From: Hill, Grace <Grace.Hill@e-lindsey.gov.uk>
Sent: 11 August 2026 17:36
To: Sutton, Catherine
Cc: _planningadvice
Subject: H23-0686-26 ecology comments

H23-0686-26 - Land to rear of Westerly Back Bank Whaplode Drove Spalding PE12 0TT
Erection of 3 dwellings, access, landscaping and infrastructure (permission extant on site for 2 dwellings)
Documents reviewed:

- Statutory Biodiversity Metric Calculation
- Biodiversity Net Gain Specification

Client:	Proposal:	Scale @ A3	Title
LGDESIGNAND BUILD	REAR OF WESTERLY, BACK BANK, WHAPLODE DROVE	1 : 250	
JANICE KENDRICK DESIGN SERVICES e-mail- jkds@talk21.com tel : 07711 007209		Dwg No. 25. 3660. 01	
BLOCK PLAN

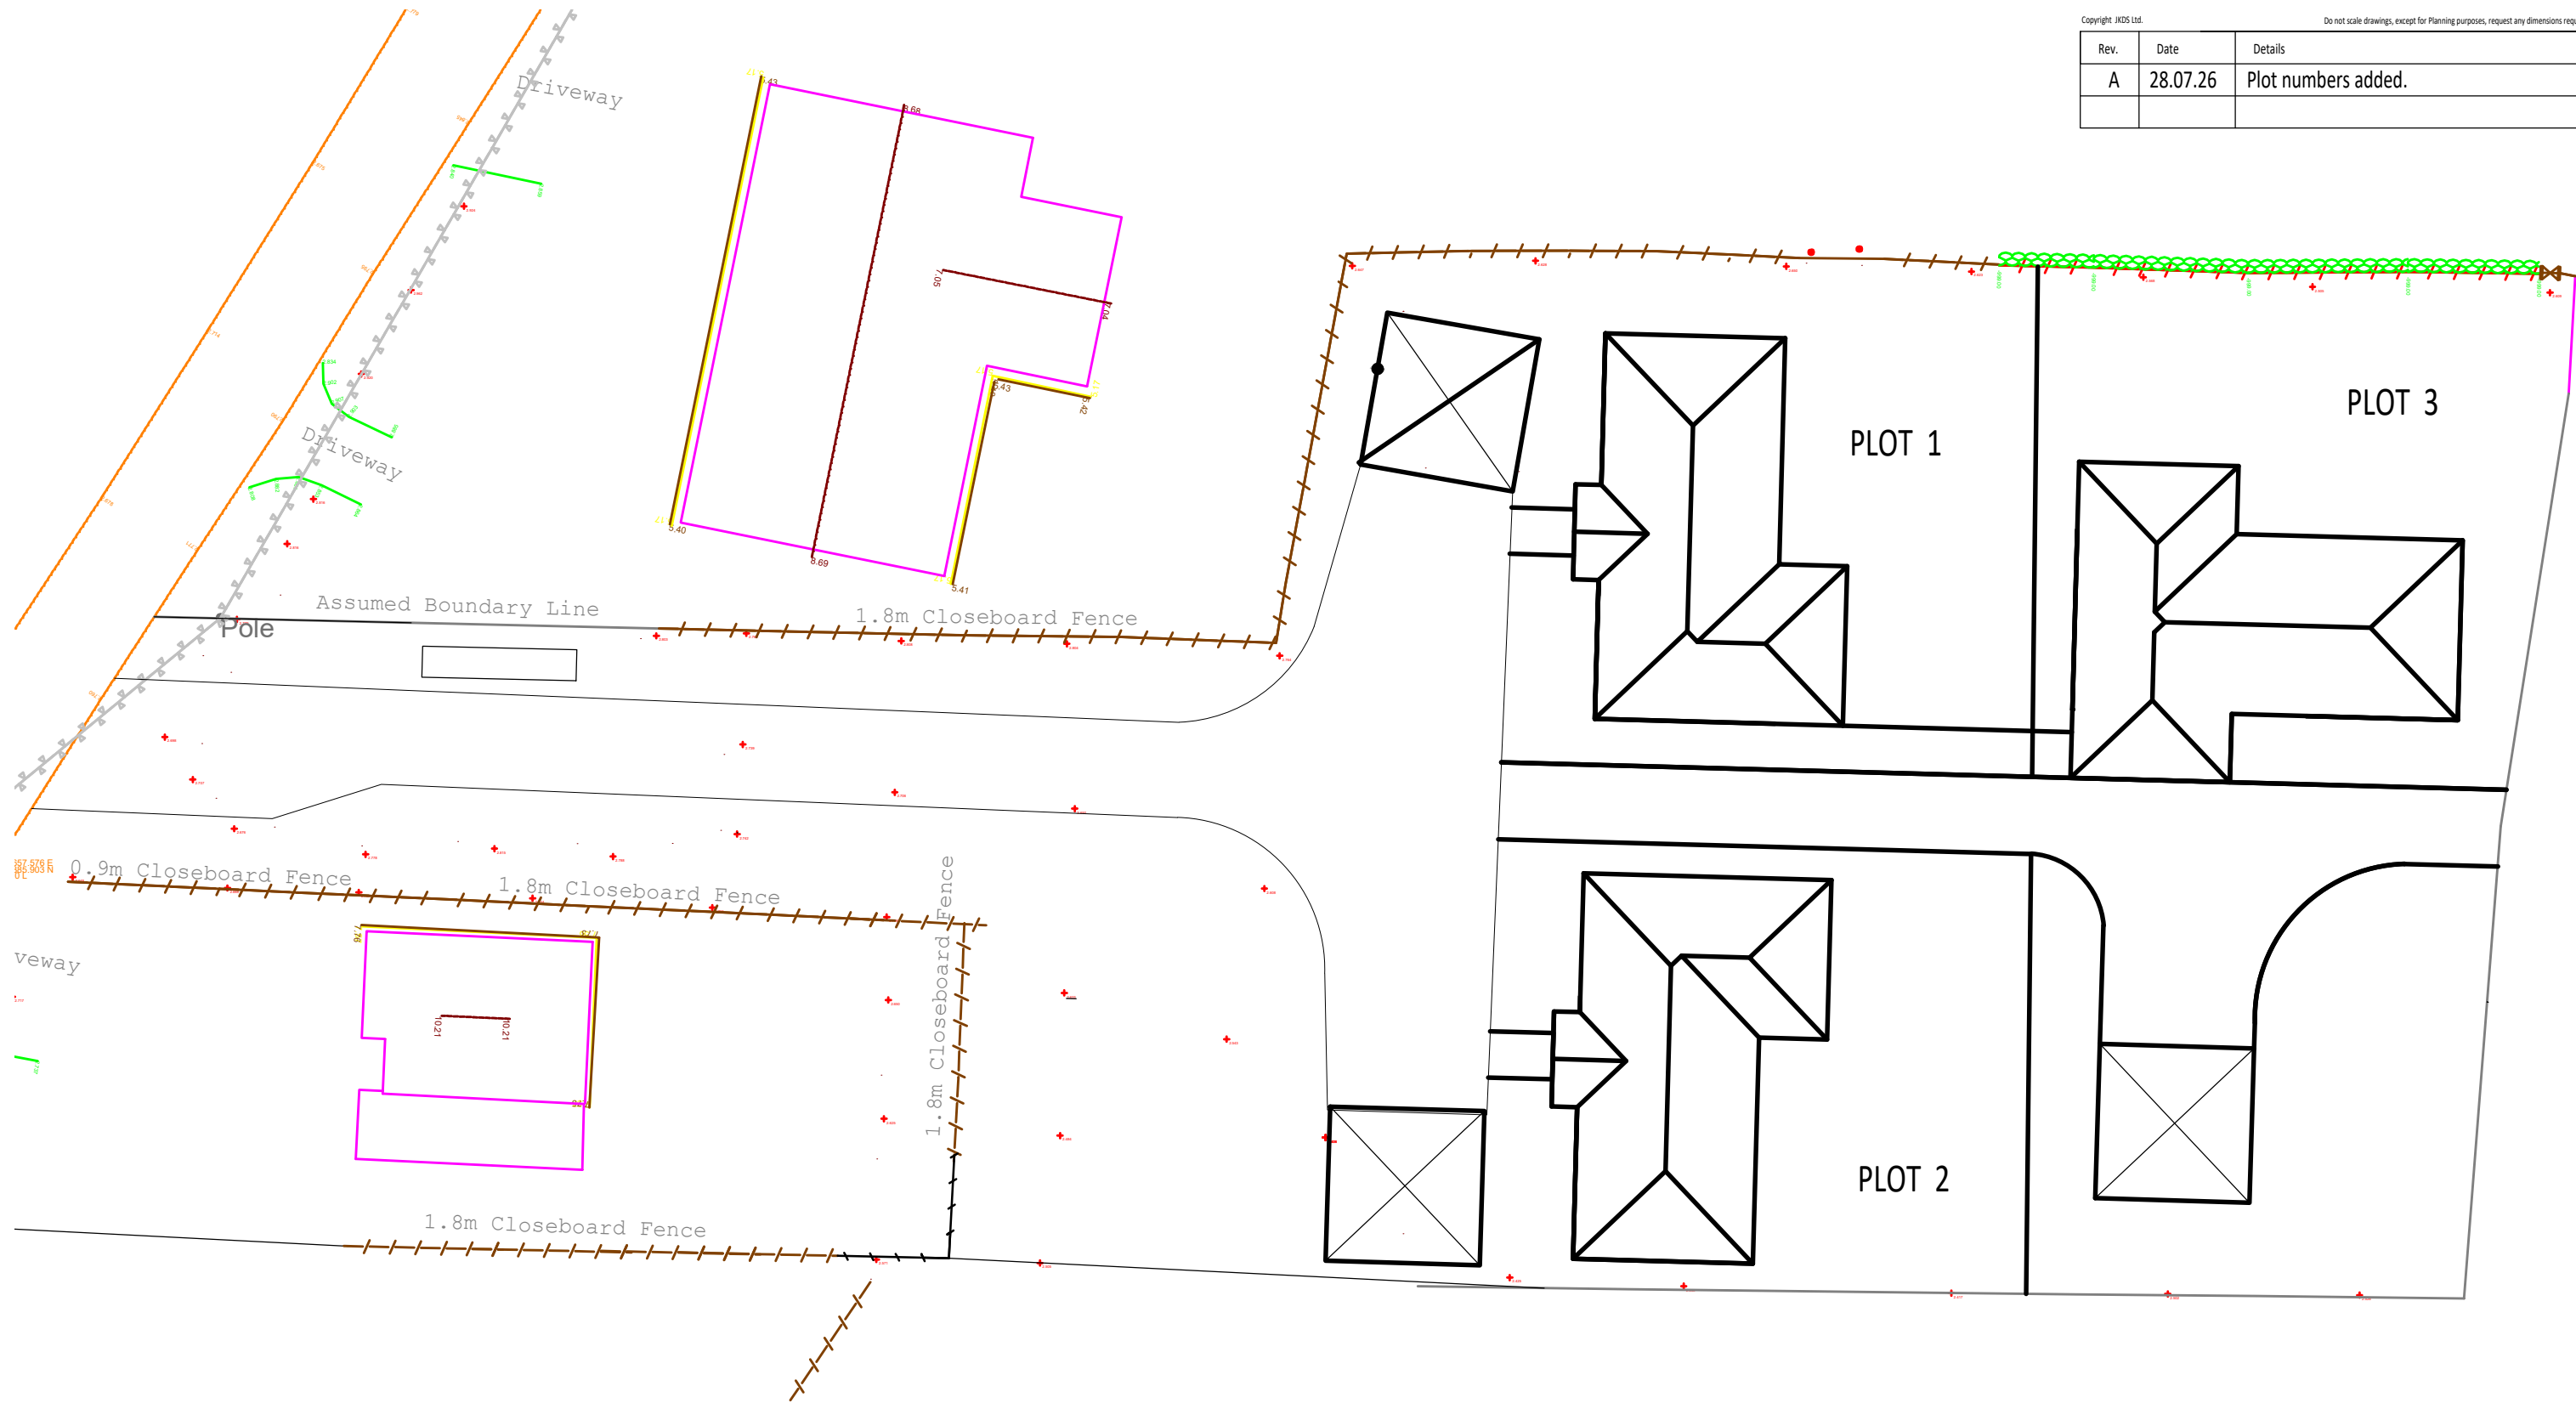
- I believe that the post-development habitats have been incorrectly classified as well.
 - At current, there is no mention of developed land creation or vegetated garden creation proposed for this application – this seems wrong given the nature of the application being the erection of 3 dwellings with associated landscaping.

- I would also argue that the open space section of this development which is currently classified as woodland would be more appropriately classified as modified grassland with individual trees planted, with both habitats to achieve moderate condition.

- I have done an estimated calculation of the post development habitats based off the site plan provided for this application:

○ The results of these alterations to the post-development habitats results in a net loss of 47.14% and a unit deficit of 2.15 habitat area units will need to be secured pre-commencement for this application.
